BCA & Access Assessment Report

Proposed Multi Level Warehouse Facility
49 Stephen Rd. Banksmeadow, NSW 2019

Revision 7
25 March 2026
Reference: 230396

1 LEVEL 1 M 1 : 500

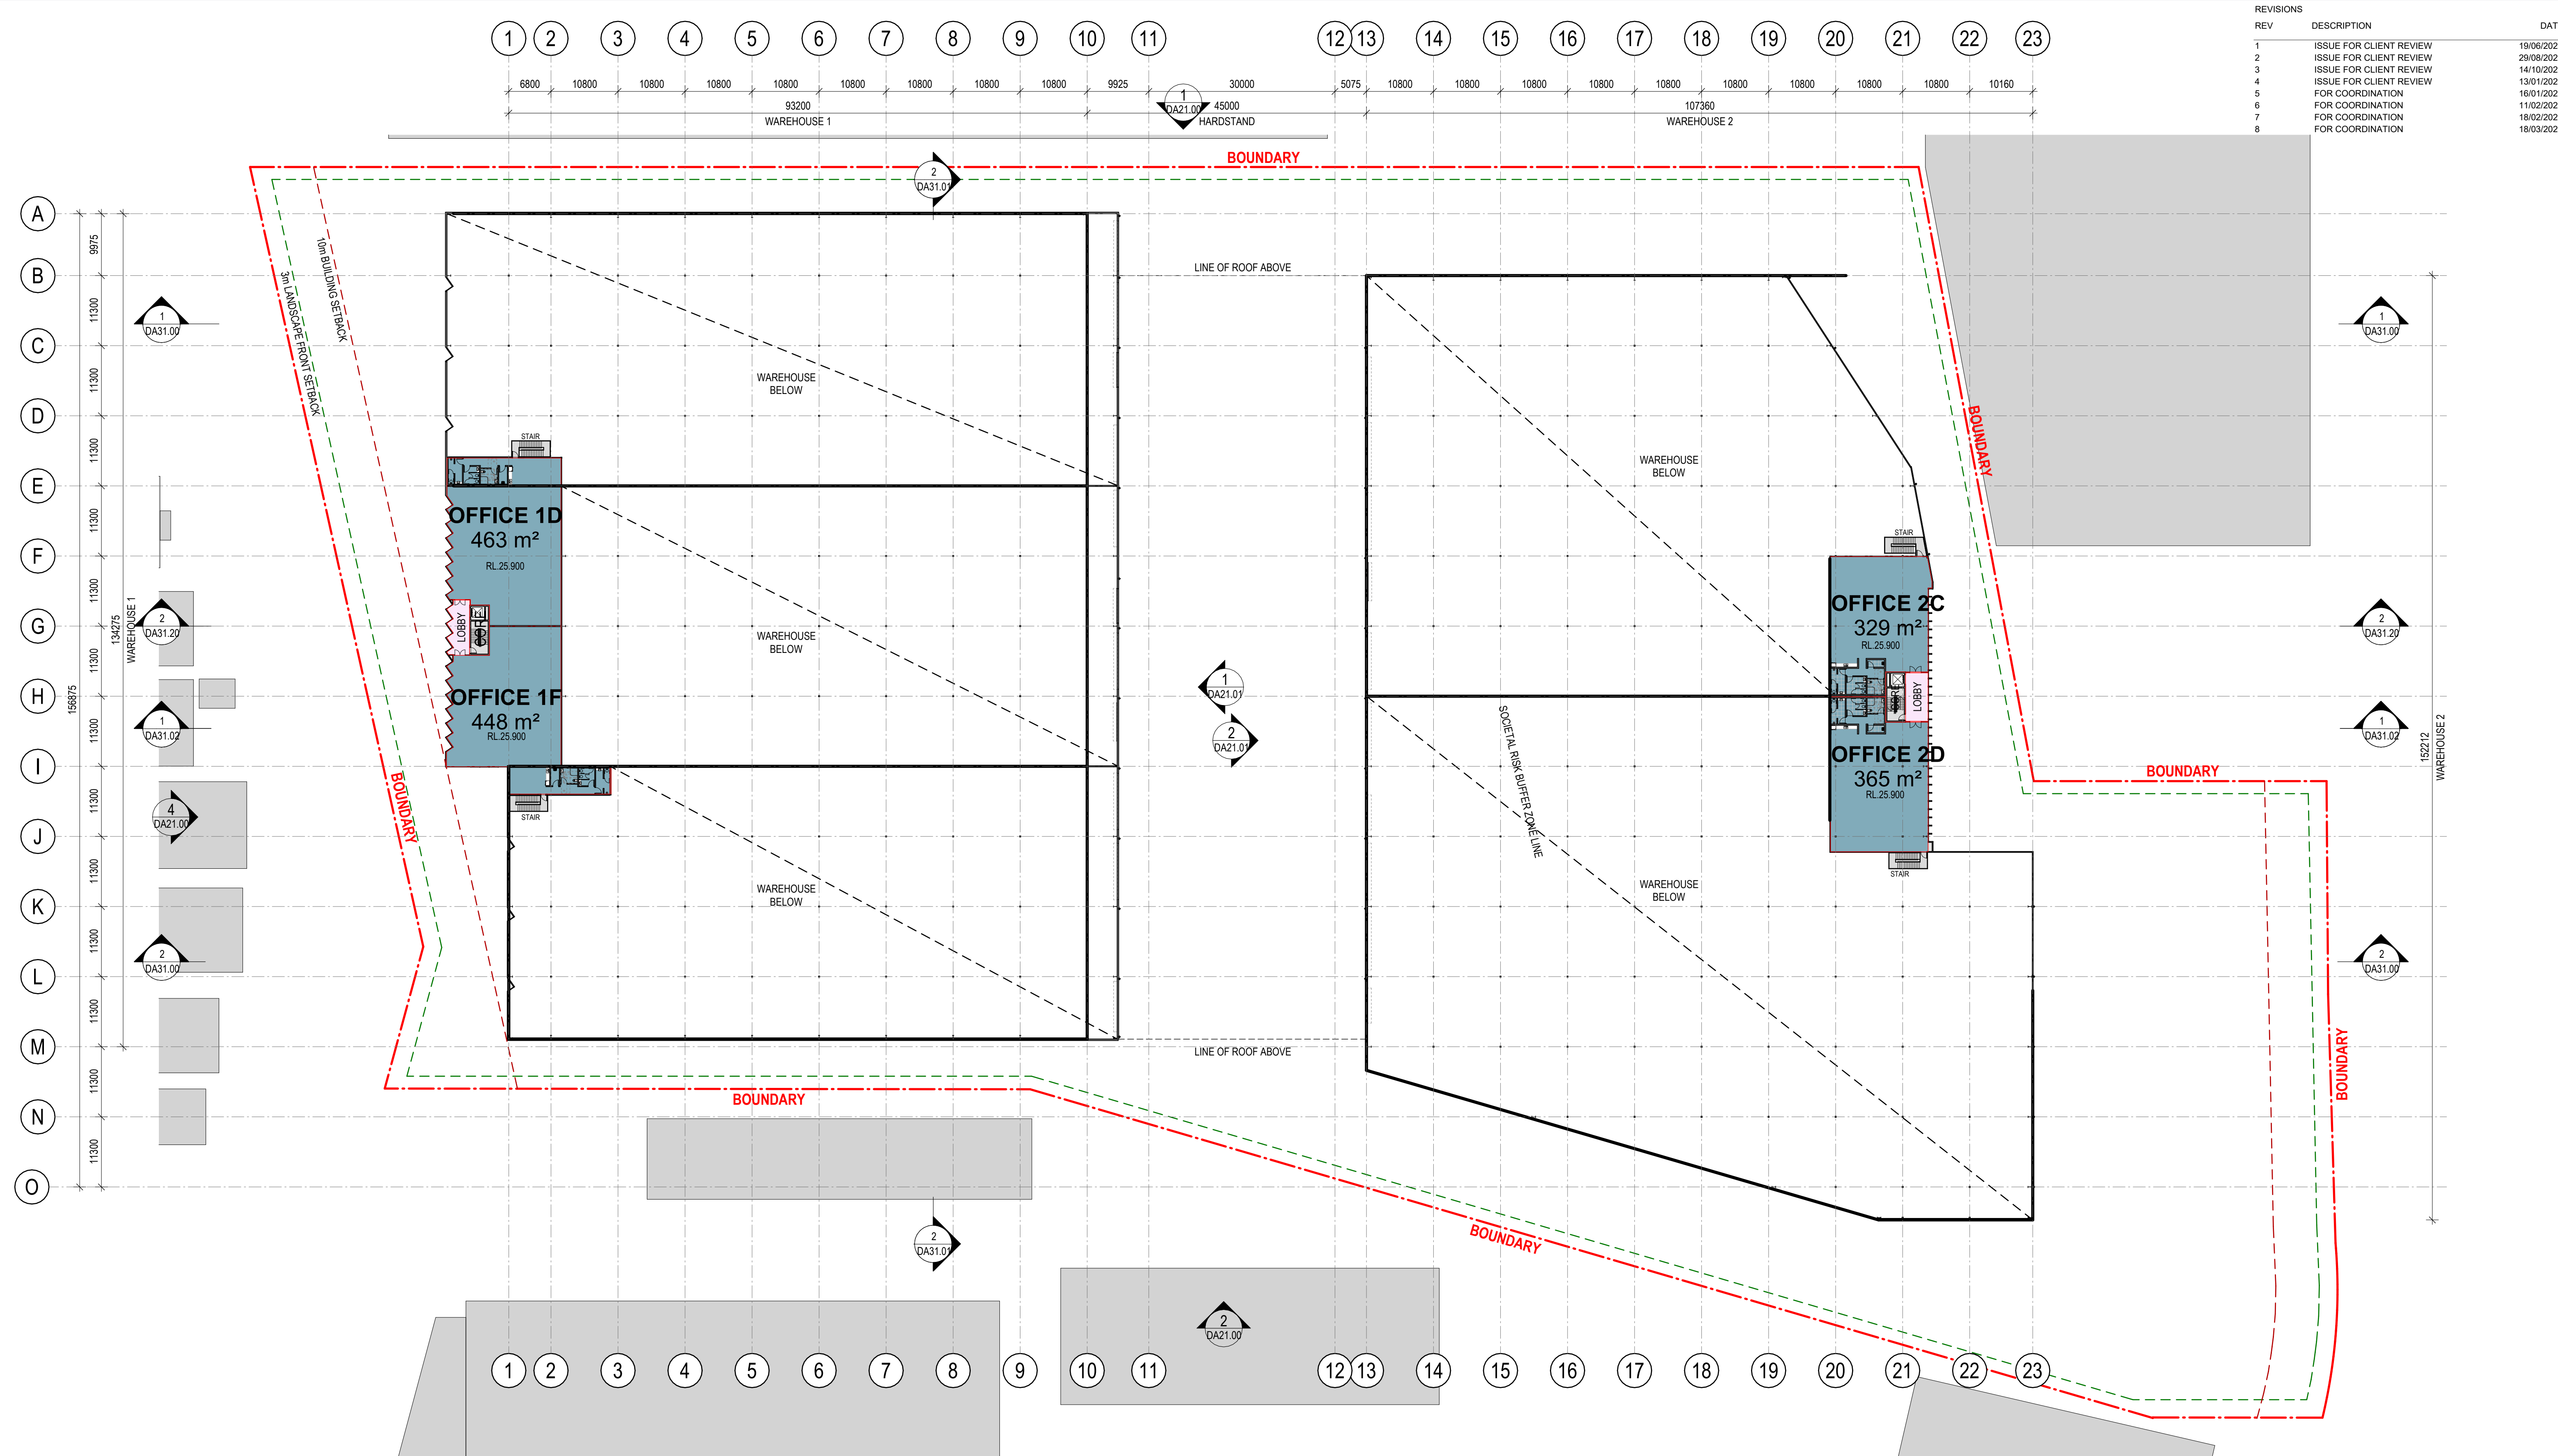
+ BCA (DtS) Clause		+ Description
7.	D2D14	+ Travel via non-fire isolated exits from the L1 Mezz. Office 1D, 1F, 2C, & 2D – exits do not provide a continuous path of egress to the level of road or open space. + The discharge of the non-fire isolated stairs from Warehouses 1A and 2D are greater than 40m from an exit to open space.
8.	E1D3	Confirmation is to be provided if 50m fire hose reels are proposed to be utilised in the Class 7b areas of the buildings to determine if a Performance Solution is required from the Fire Engineer.
9.	E1D2 & E1D4	Further design development is required with respect to the location of the sprinkler booster assembly to determine whether a Fire Engineered Performance Solution is required.
